PROJECT: SANTRY AVENUE STRATEGIC HOUSING DEVELOPMENT

**REPORT: STATEMENT OF RESPONSE TO AN BORD PLEANÁLA'S NOTICE
OF PRE-APPLICATION CONSULTATION OPINION: REF: ABP-
308093-20**

CLIENT: DWYER NOLAN DEVELOPMENTS LTD.

DATE: 16|07|21

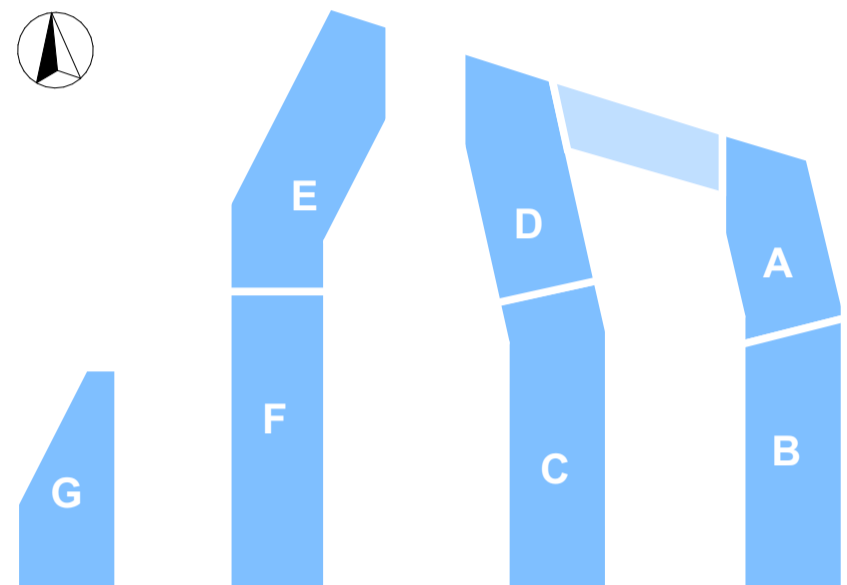
Item 1. (a) While the planning authority is satisfied with the general layout of the blocks, although there are concerns regarding Block G, located in the south-western corner of the site. The relationship of this block with the rest of the scheme and the outdoor amenity space(s) to serve this block require a fundamental redesign. This block should form an integrated part of the scheme and not form a standalone block in the corner of the development underserved by outdoor amenity space.

Response: The submitted site layout plan (D1809-P.03 clearly illustrates that Block G has been repositioned within the development, closer to Blocks E/F and the main access route into the development from Santry Avenue moved westwards adjacent to the site boundary. Block G and its amenity space are no longer proposed removed from the rest of the development but is more integrated into the overall development.

(b) There are concerns regarding the proposed separation distances between some blocks at certain 'pinch points' in the scheme. For example a minimum of 12 metres separation is proposed between the balconies on the eastern elevation of Block E and the bedroom windows on the western elevation of Block D. It is not considered that this minimal distance as proposed can adequately maintain the privacy of future occupants and this layout should be reconsidered and separation distance increased.

Response: The separation distances between the proposed buildings are detailed on the enclosed site layout plan (D1809.P.03) and range from a minimum of 18m to a maximum of 26m.

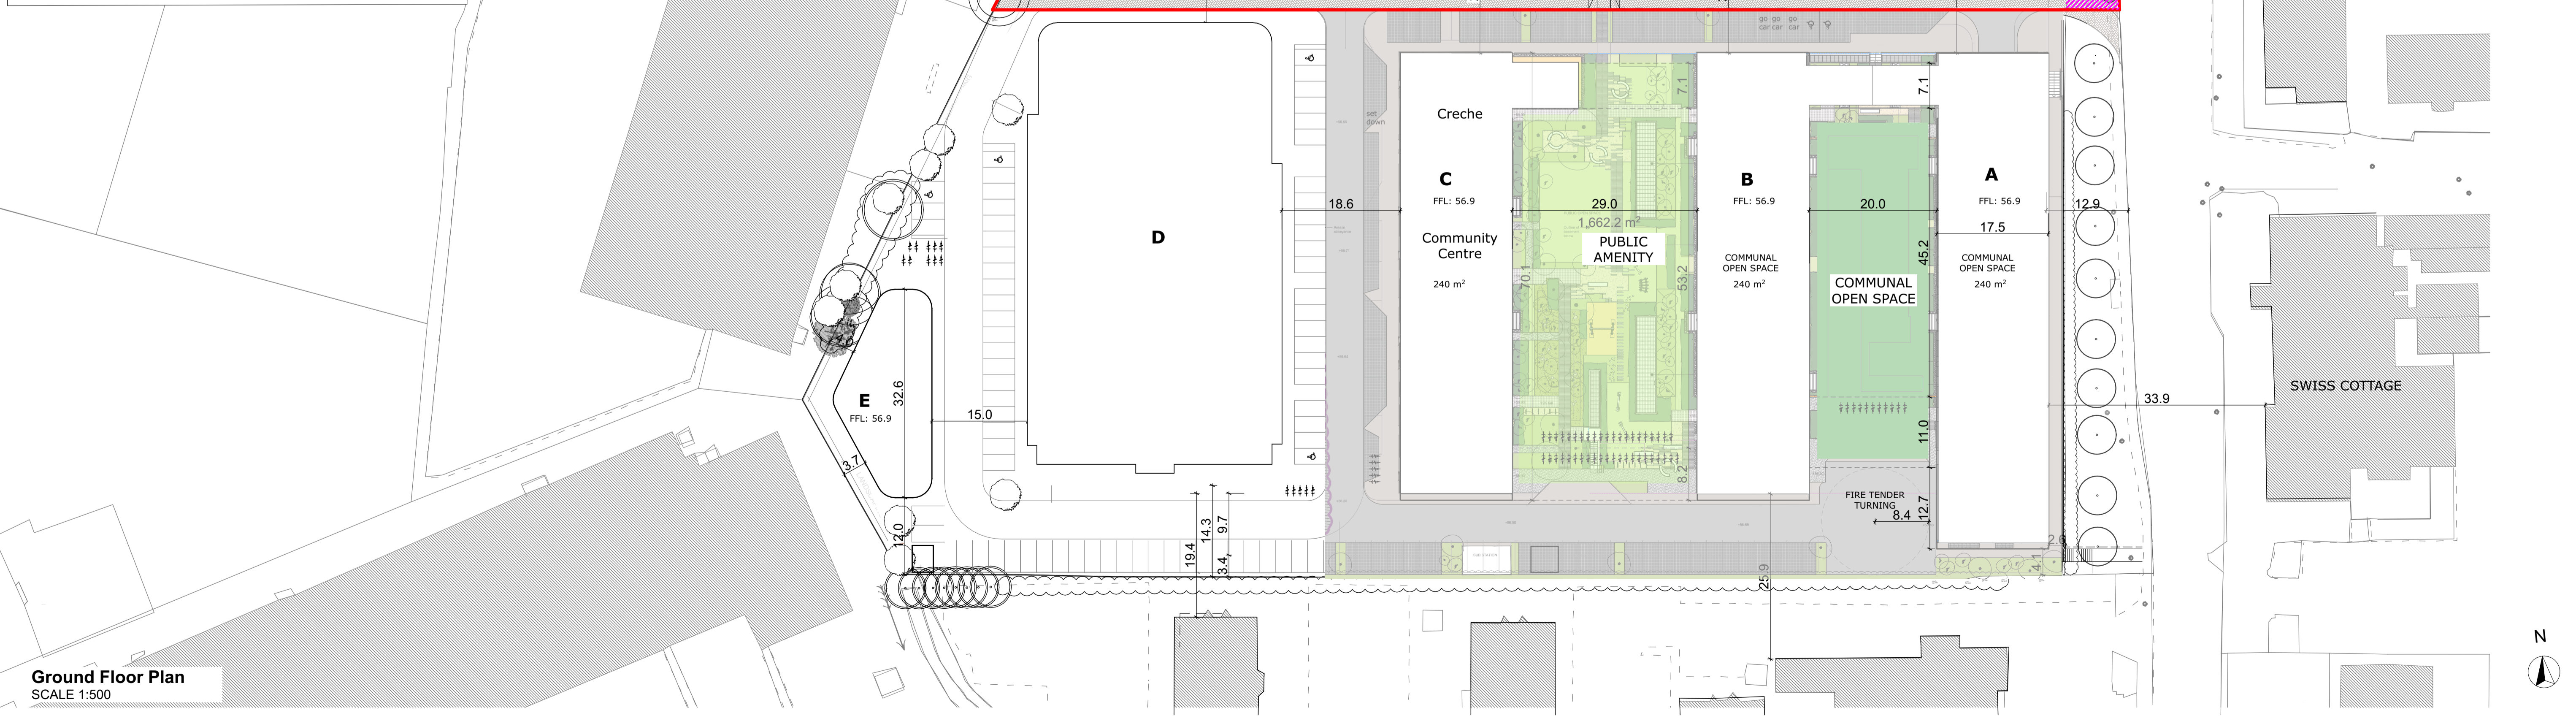
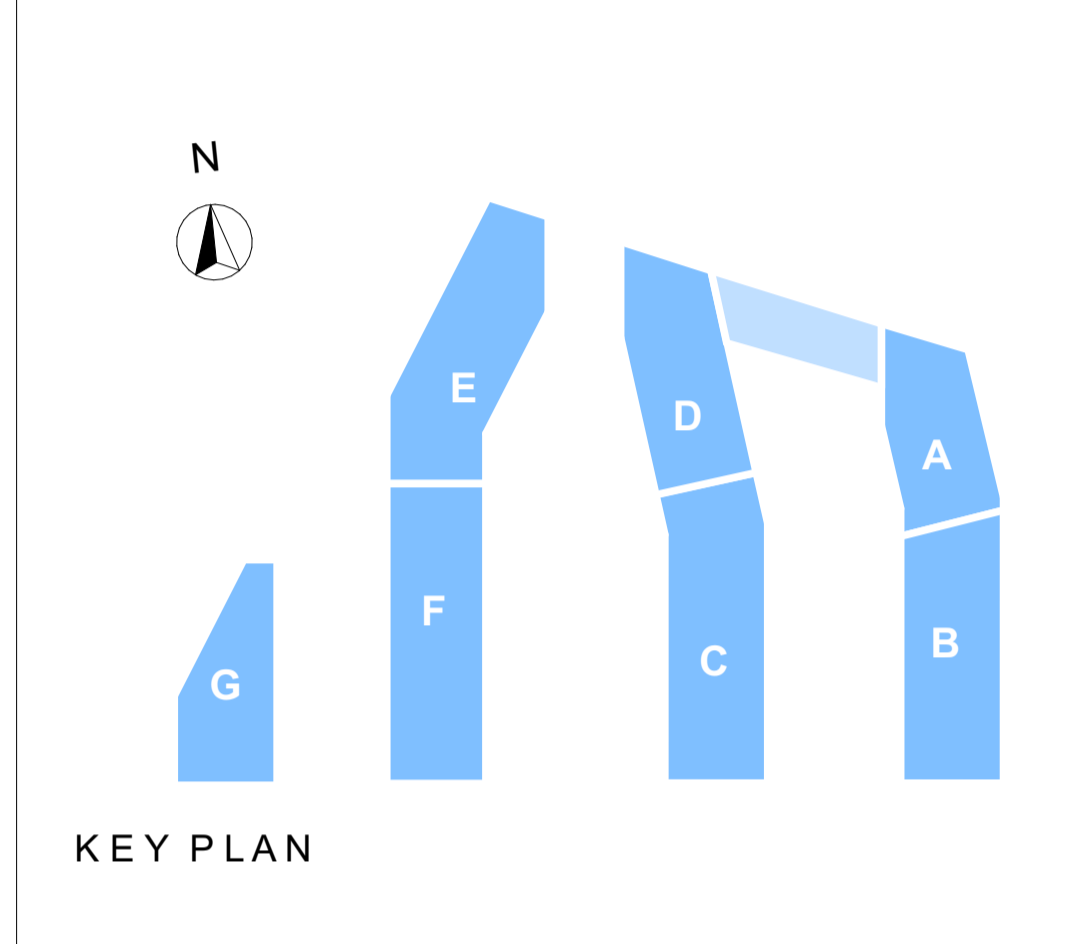
Item 6 - *A site layout plan, which clearly indicates what areas are to be taken in charge by the Local Authority.*

Please refer to drawing no. D1809.P04 “Site Layout – Taking In Charge” prepared by Davey Smith Architects which identifies the areas of the proposed development that are proposed to be taken in charge upon completion of the development. The remainder of the development will be in the charge of a management company, with details set out in the enclosed Property Management Strategy.

Section L-L  
SCALE : 1:200

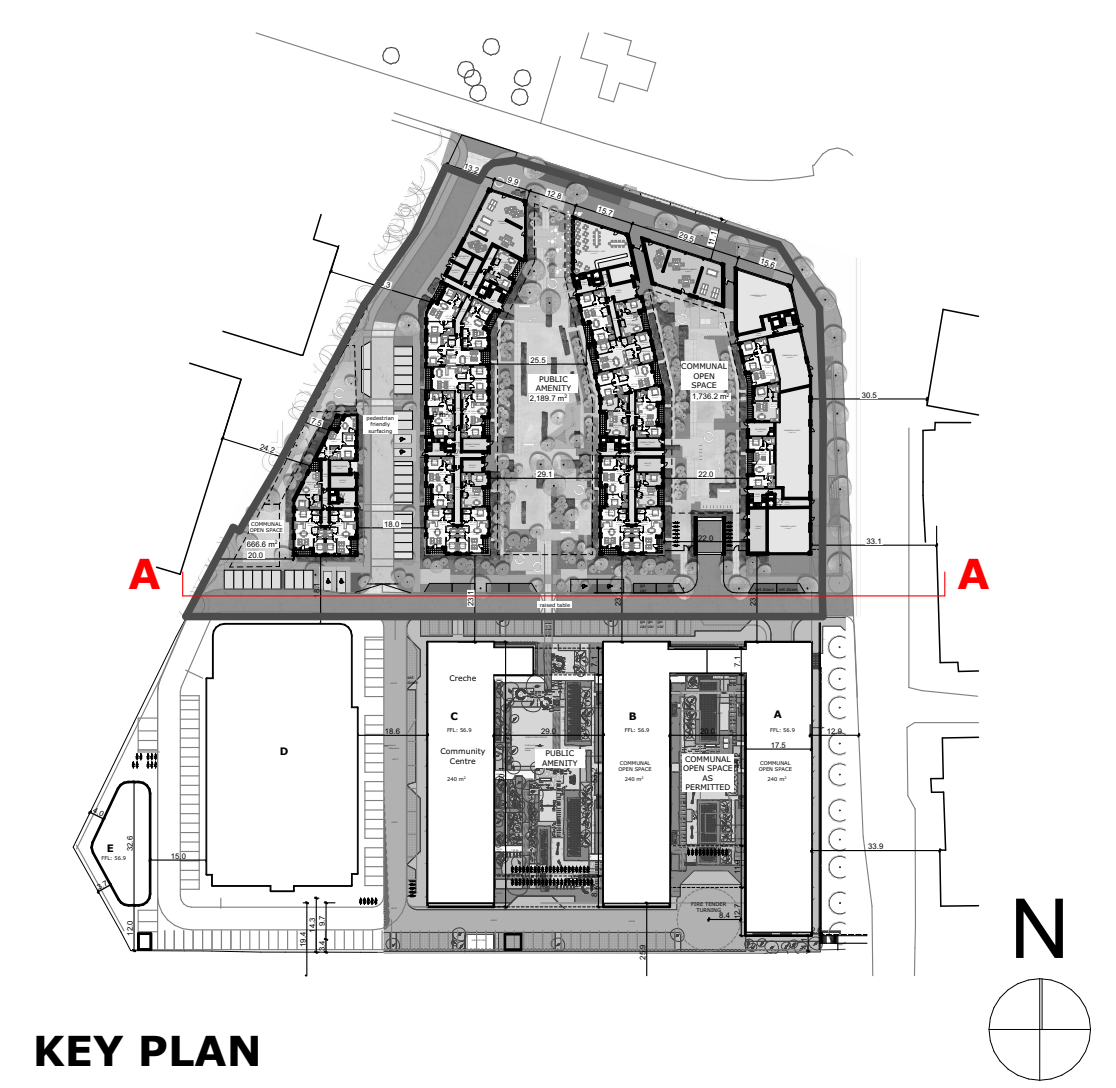
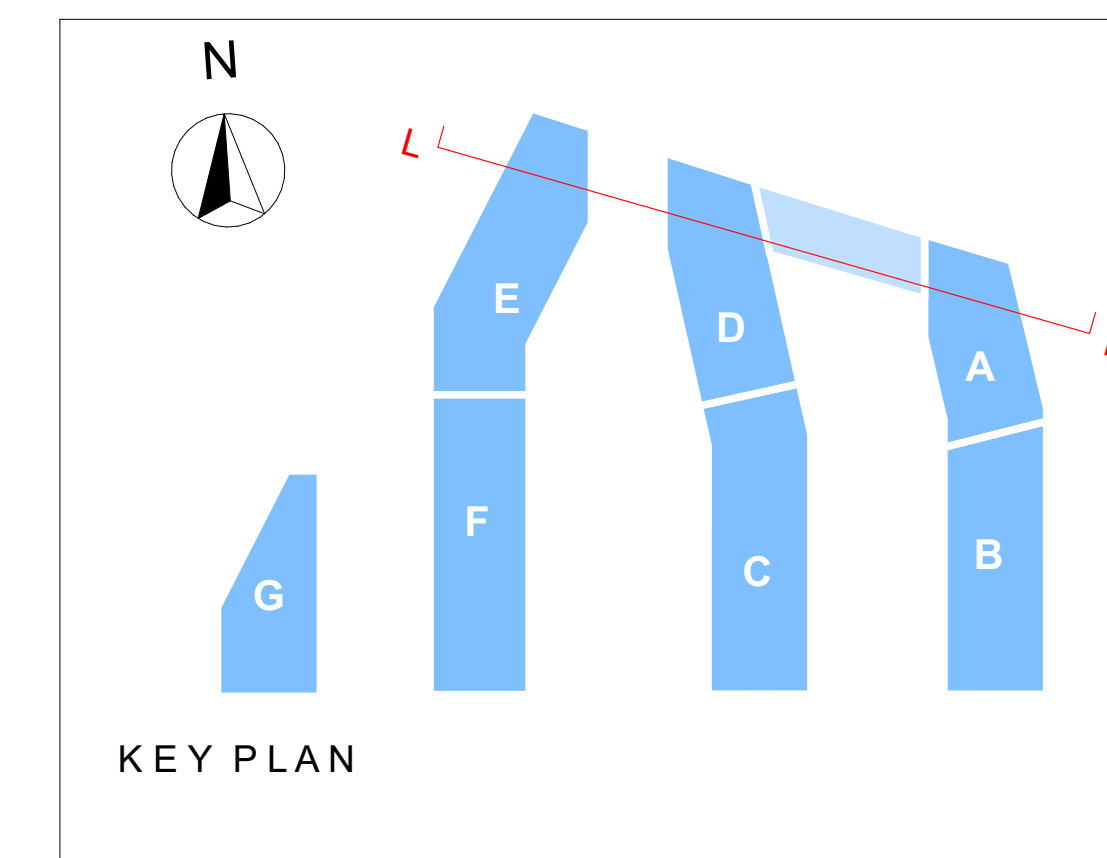
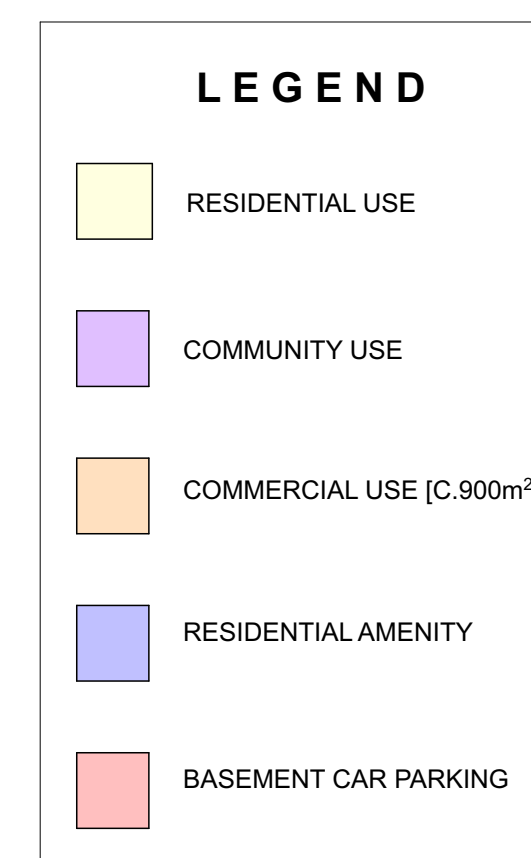
Item 3 - *Cross sections that detail public realm, landscaping and apartment block interfaces at various locations, but specifically where levels change and where space is limited. Locations for analysis should include, but are not limited to; along the Swords Road, the interface with Santry Place to the south, surface car parking areas and the planned plaza space along Santry Avenue to the north. The applicant is urged to consult the Design Manual for Urban Roads and Streets, with particular reference to streetscape, the pedestrian and cyclist environment and carriageway conditions.*

Both Davey–Smith Architects and Dermot Foley Landscape Architects have prepared drawings illustrating the sections through the site, including details of site levels – please refer to the following enclosed drawings:

- Drawing No. D1809.P27 'Blocks A-G Section K': Scale: 1: 200@A1
- Drawing No. D1809.P28 'Blocks A-G Section L & Contiguous South Elevation' Scale: 1:200@A0
